COLORADO
Department of Transportation

November 22, 2022

RE: 1041 Meadow Lake Airport Expansion - AASI222

AIRPORT LAYOUT PLAN - FUTURE		
CDAG GRANT NO. 2014-FLY-01	JVIATION PROJ. NO. 2014.FLY.01	DATE: MAY 2019

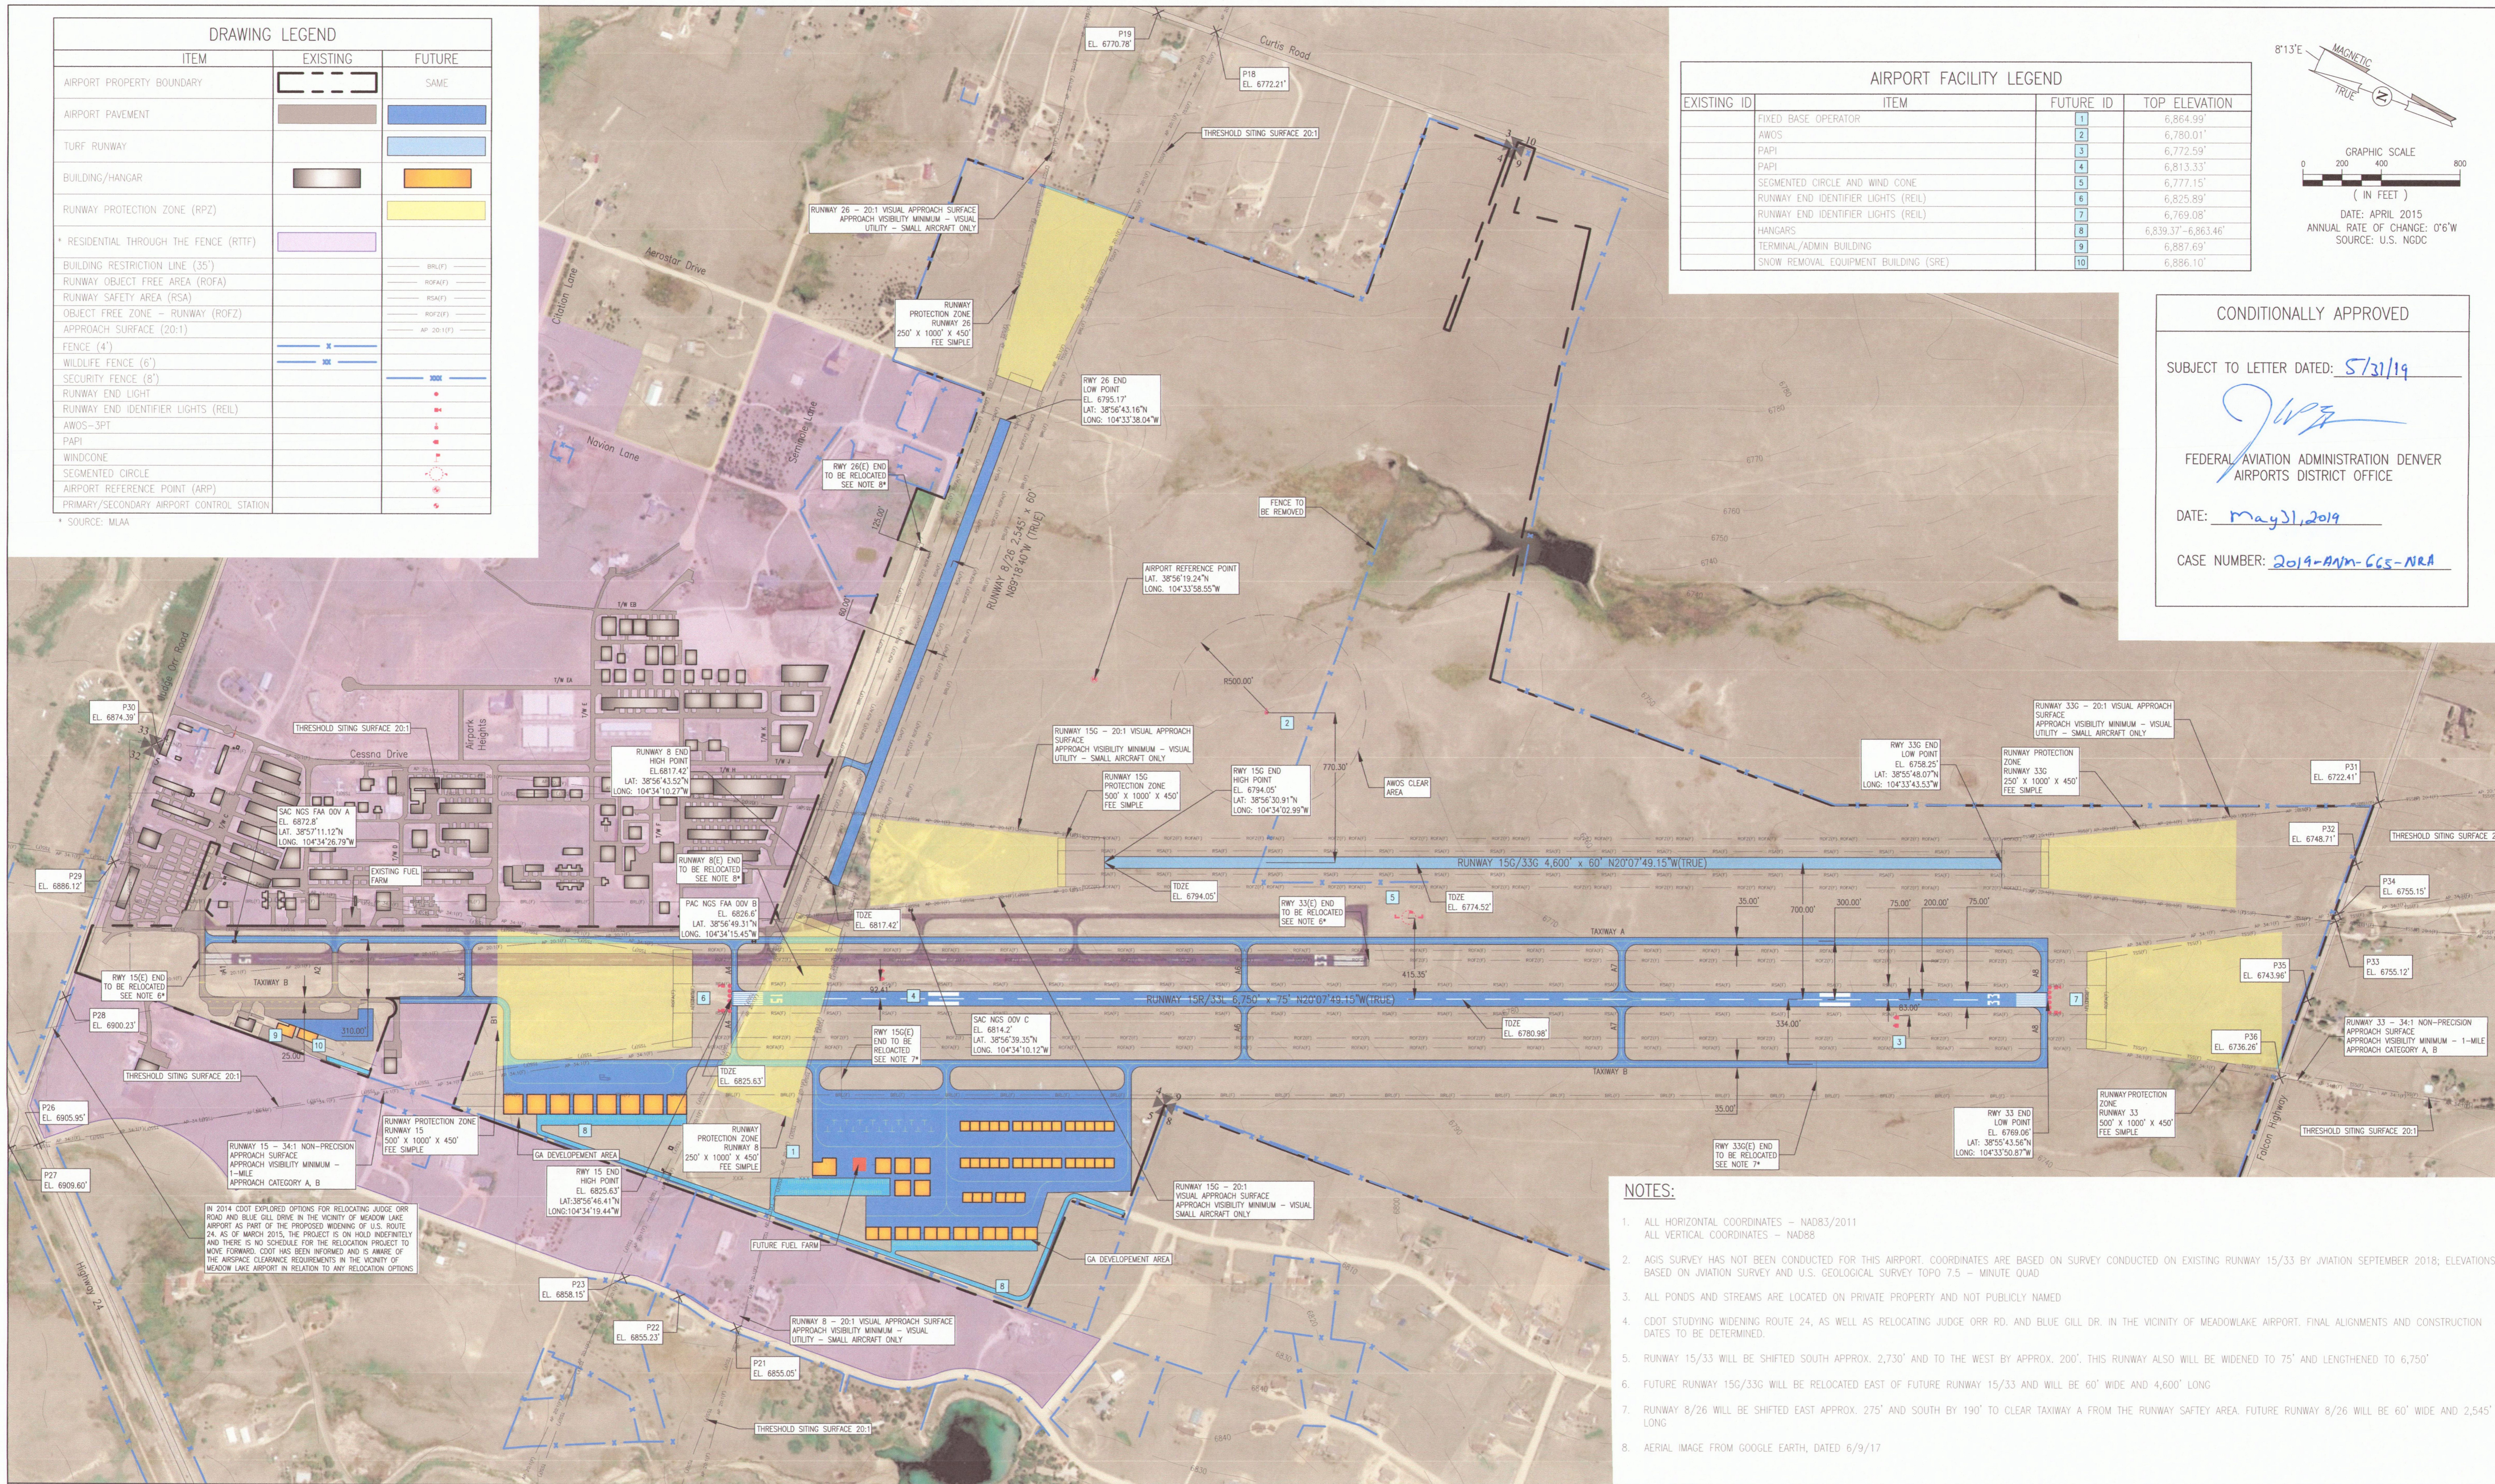
- The Airport Layout Plan and Airport Master Plan have a few references to the widening of US 24 and/or the Judge Orr intersection improvements no schedule date of construction but is in the design phase.

- The documents do not include the US 24 PEL Study and it’s not referenced in the 1041 Letter of Intent. Instead, the Airport Master Plan and other documents reference the previous work at Judge Orr. A better comment for them would be to reference the planning work done with the PEL study and the widening and intersection conceptual plans in that area, since it’s more current than what is shown in the Master Plan.
